**WELWYN HATFIELD BOROUGH COUNCIL  
EXECUTIVE DIRECTOR - PLANNING, PUBLIC PROTECTION AND GOVERNANCE**

**DELEGATED APPLICATION**

**Application No:** 6/2020/2410/HOUSE  
**Location:** 37 Sherrardspark Road Welwyn Garden City AL8 7JY  
**Proposal:** Erection of single storey rear extension, partial conversion of garage into study, internal alterations on ground and first floor and conversion of existing loft into habitable space including 4 x rear rooflights  
**Officer:** Ms Emily Stainer

**P/03**

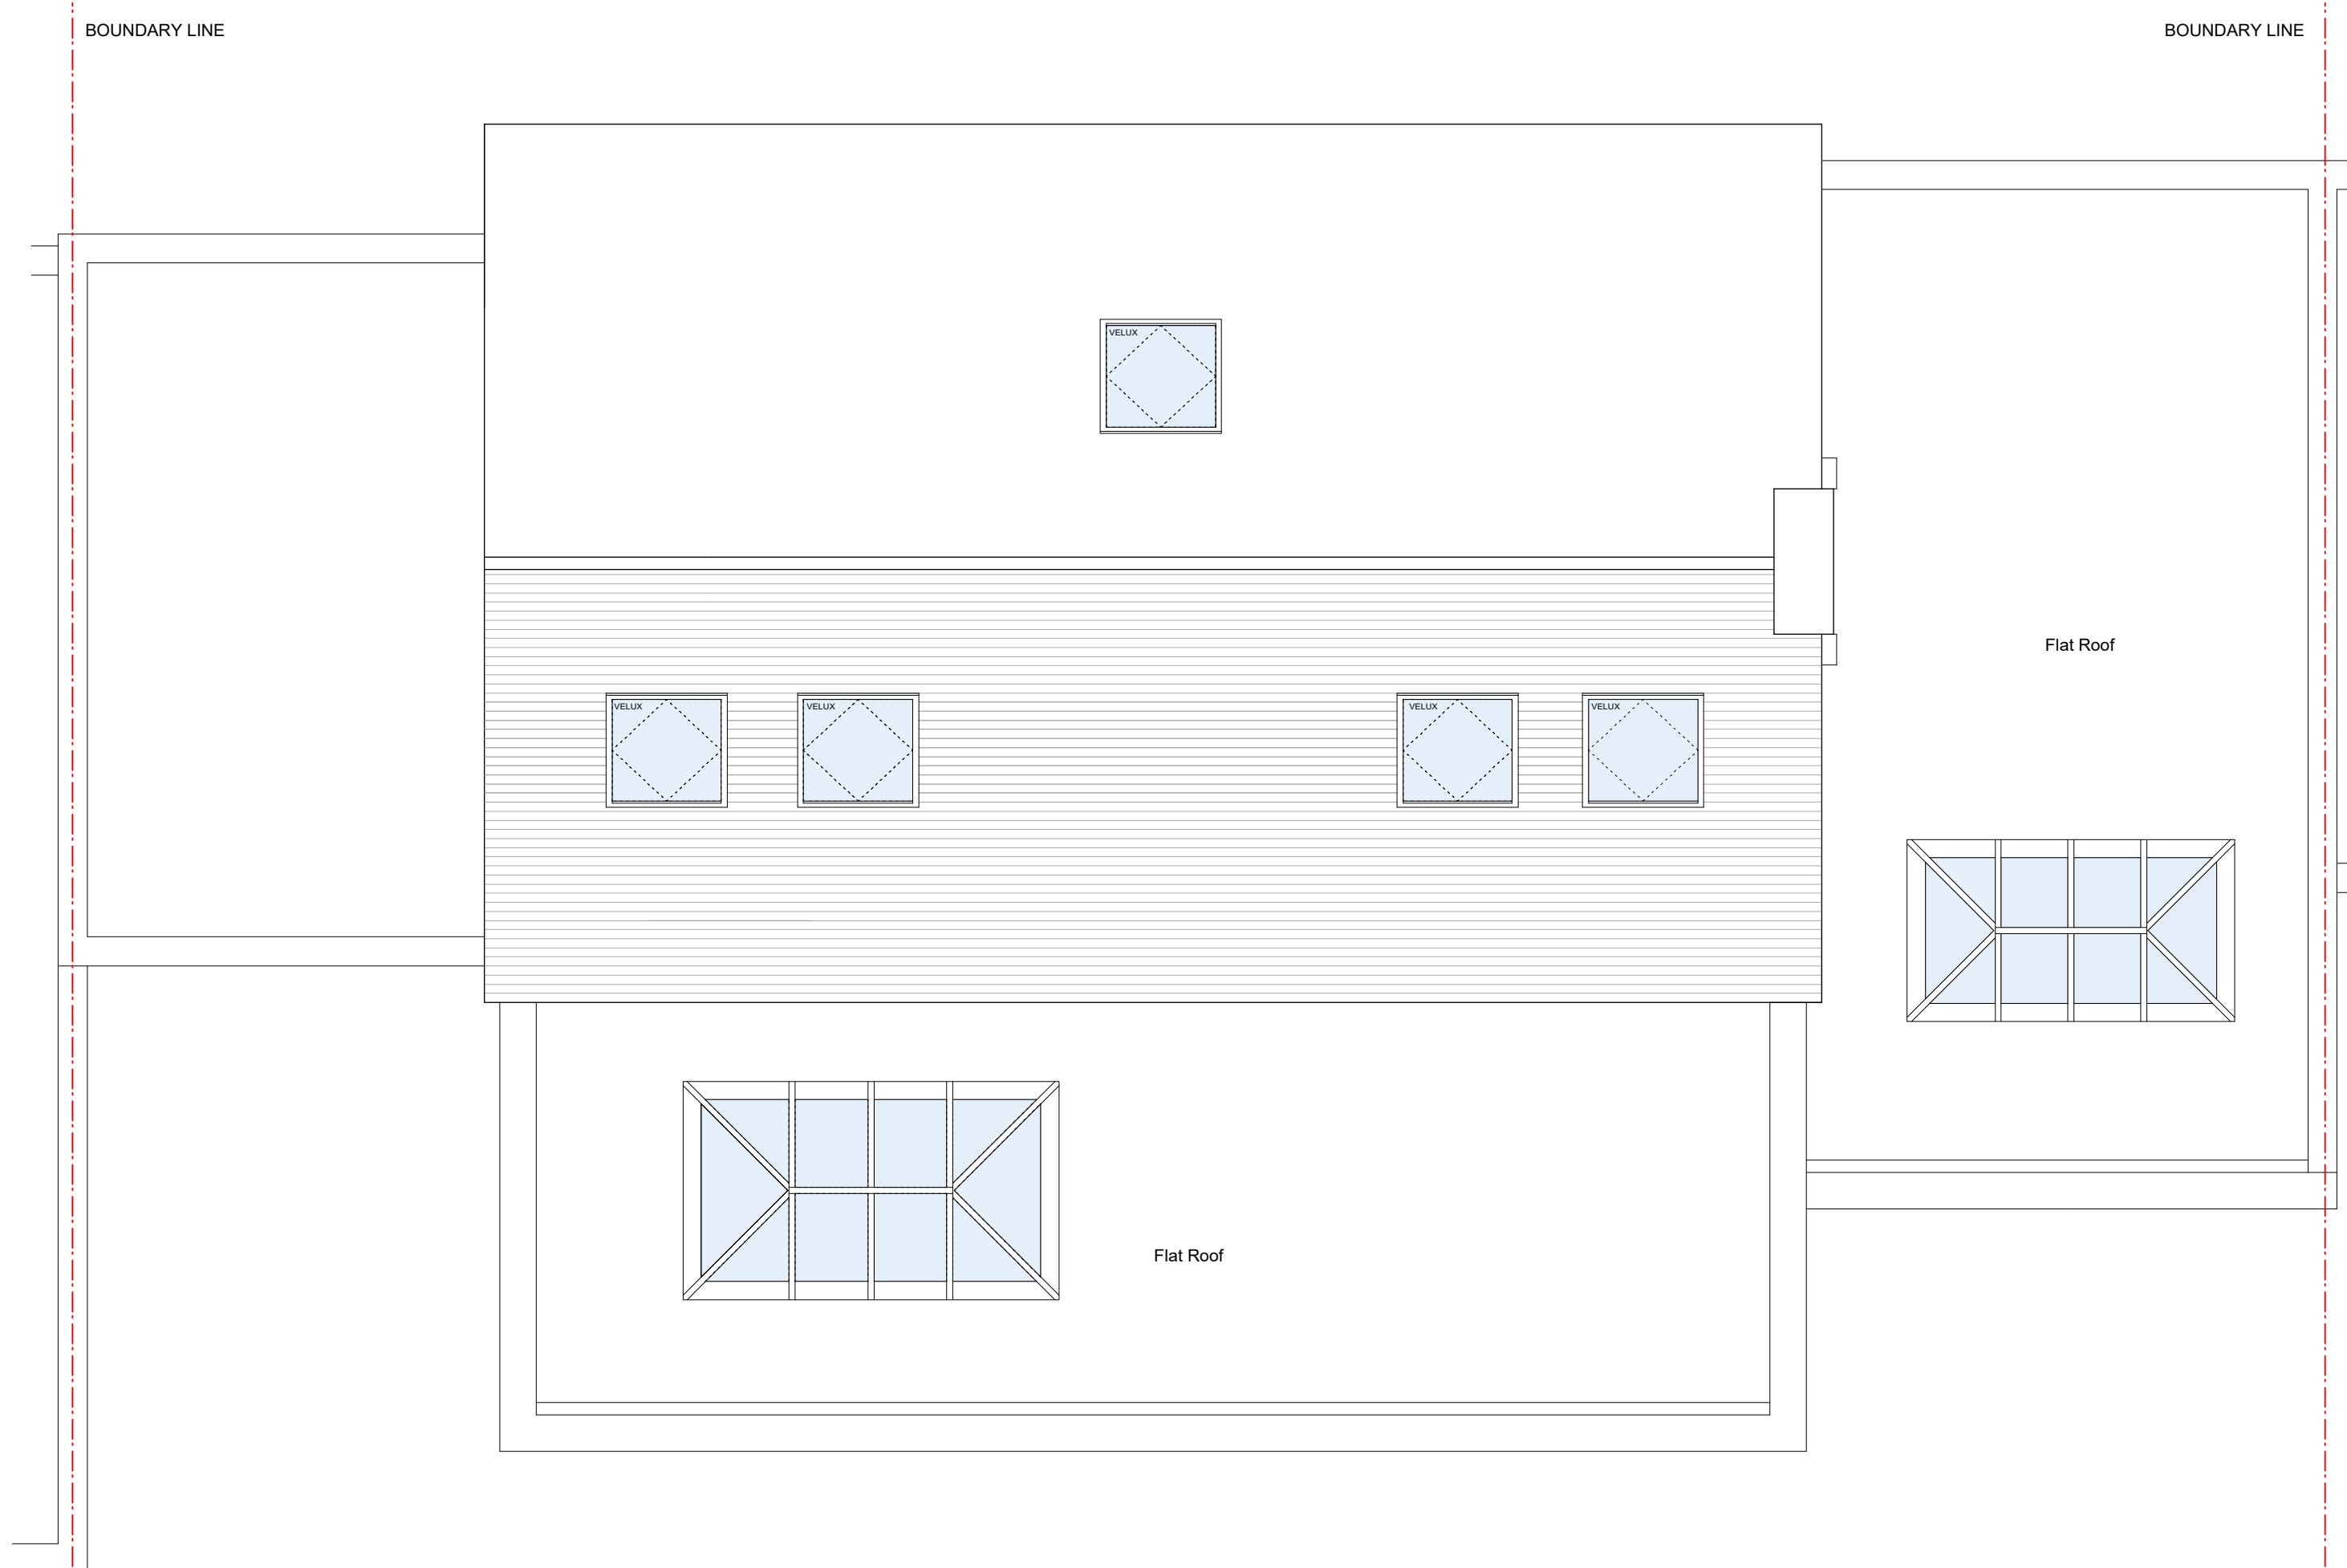
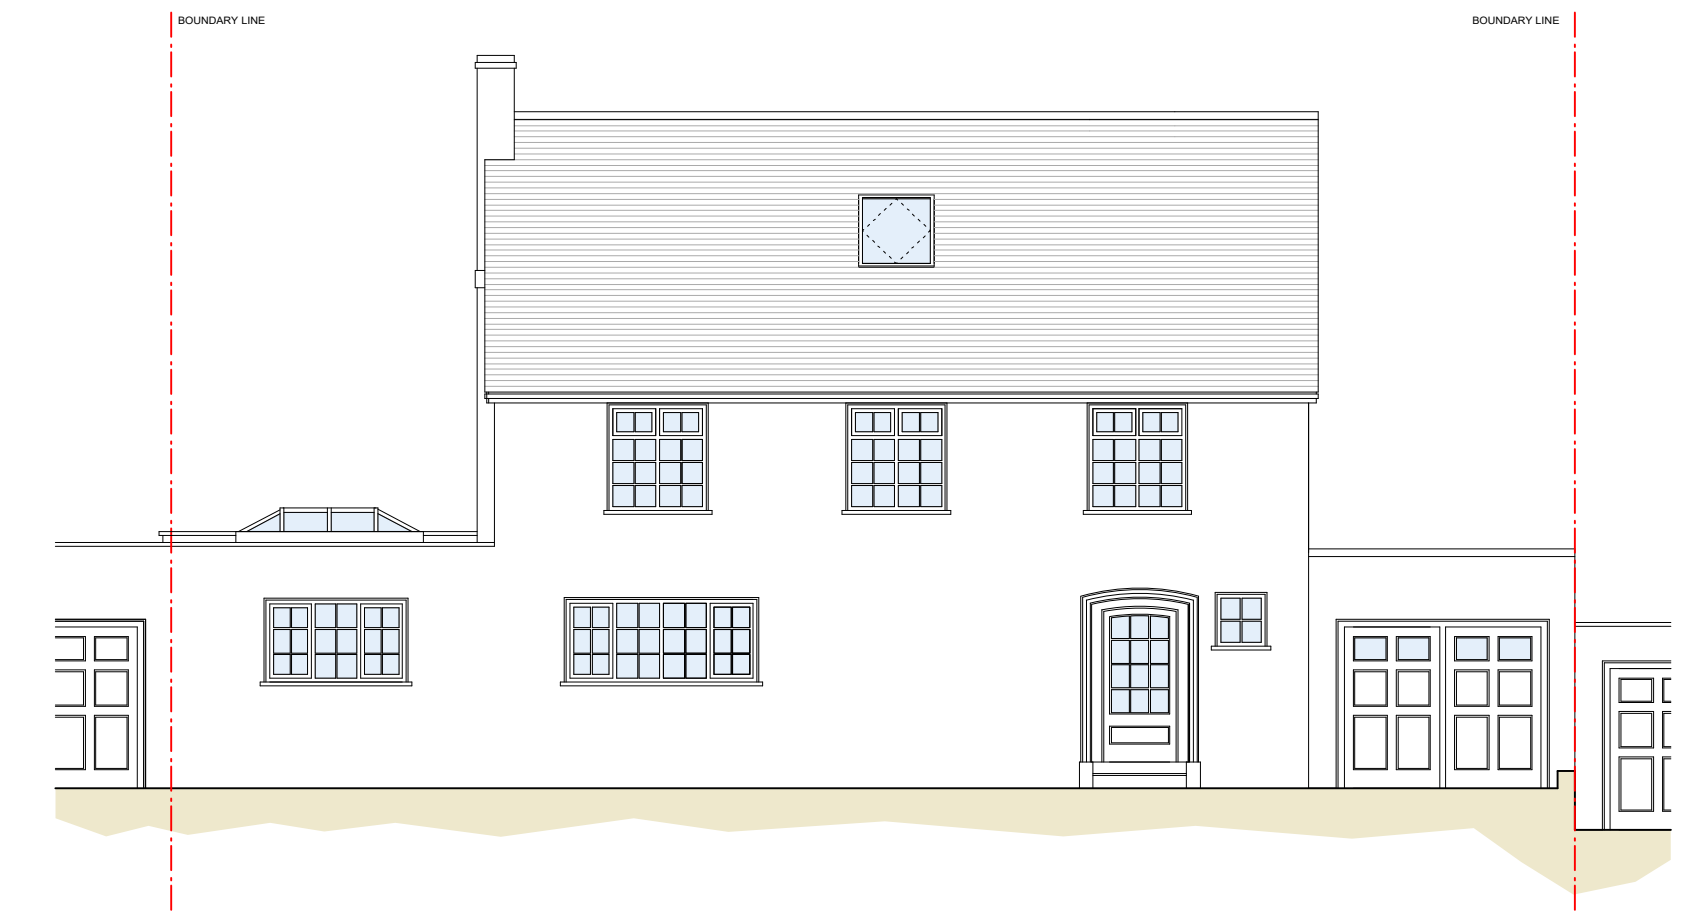
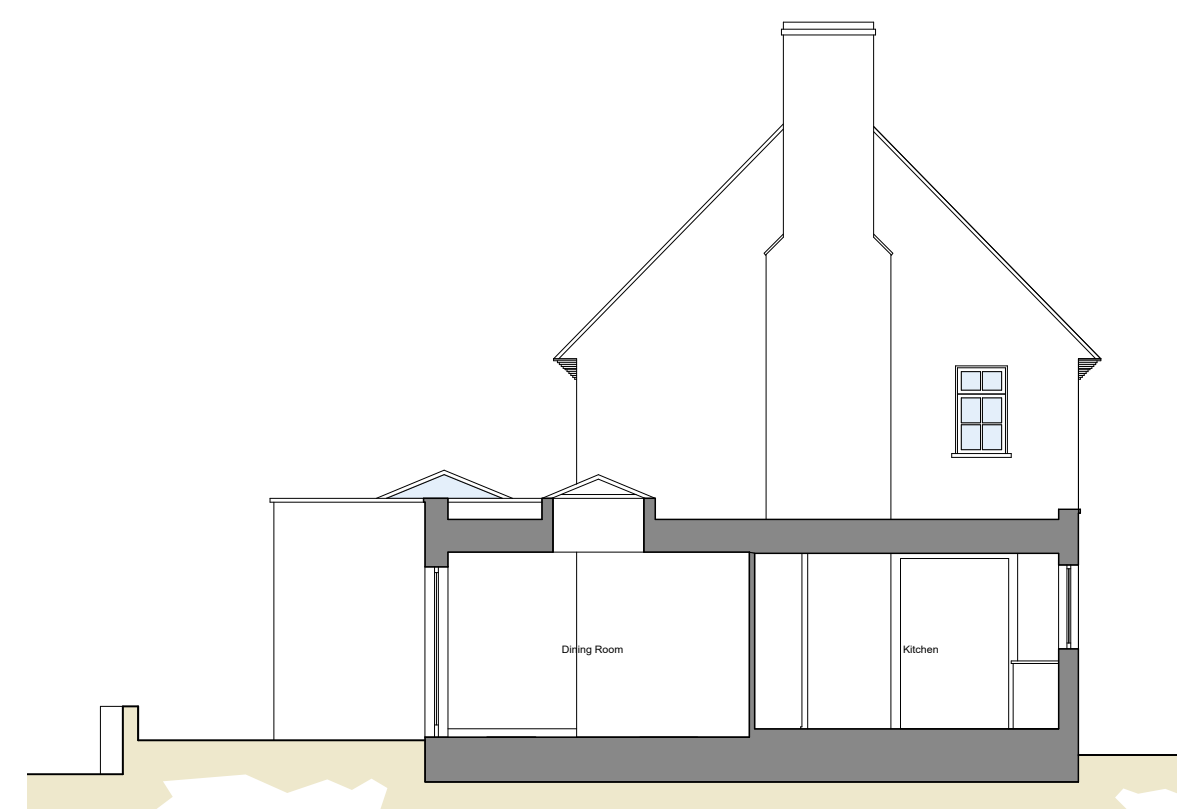
The proposed drawings have been amended during the application process to remove the front rooflight and include a flush flat roof light to the side to replace the proposed roof lantern. The proposed roof lights will be modest in size not excessively projecting from the roof slope. Given their location to the rear of the property, they would not be unduly visible from the street scene, therefore they will maintain the amenities and values of the conservation area. The proposal also involves the addition of a side gable window. This window would mirror openings on other properties in the area and provided the materials match the existing property, there is no objection raised. New ground floor windows would also be acceptable subject to the materials matching.

DRAWING NUMBER
P/02

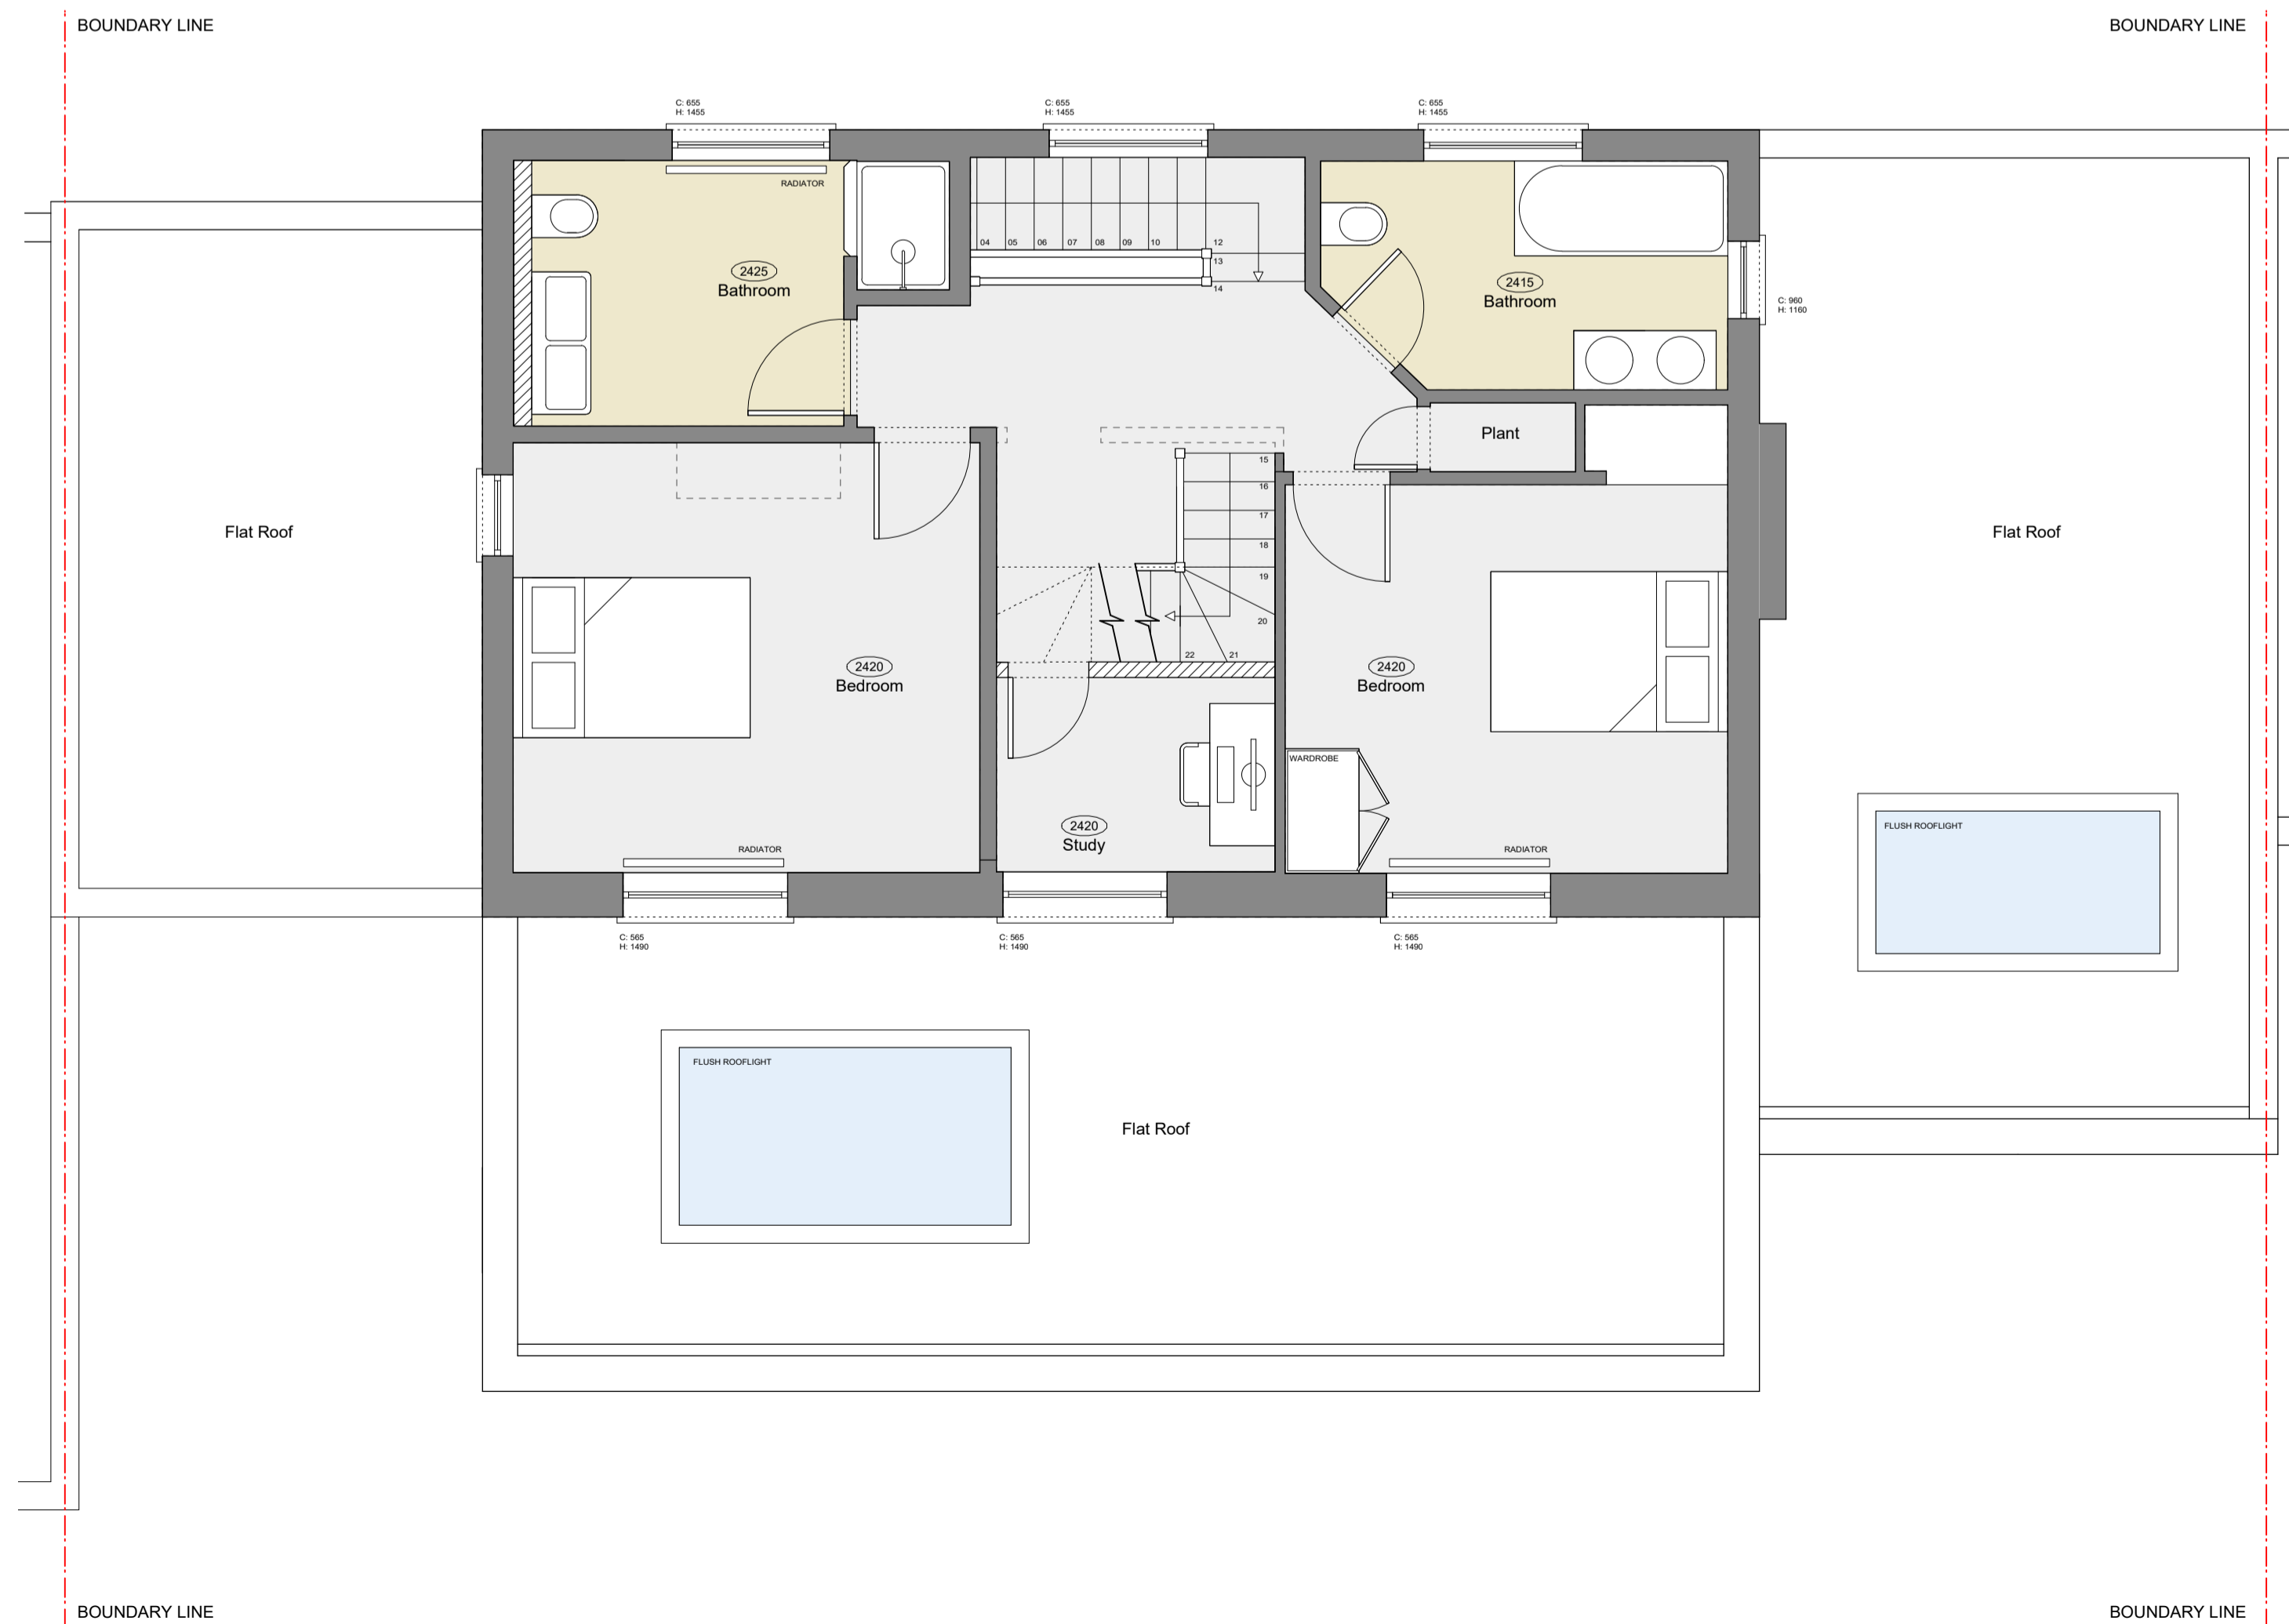
Although it would extend some depth into the rear garden, the proposed extension would be of single storey nature and feature a roof height of approximately 3.6 metres above ground floor level. In the context of a wide and spacious plot, the extension would appear subordinate to the main dwelling. Moreover, a functional rear garden would also be retained. Given its siting with the majority of the extension only visible from the rear of the property, it is considered that it would not have a detrimental impact on the visual amenity of the street scene or the Conservation Area. The materials proposed would also match the existing property, which can be secured by condition. Overall there are no objections to policies D1 and D2 and it is considered the proposed alterations would respect the built form of the existing dwelling and surrounding area.
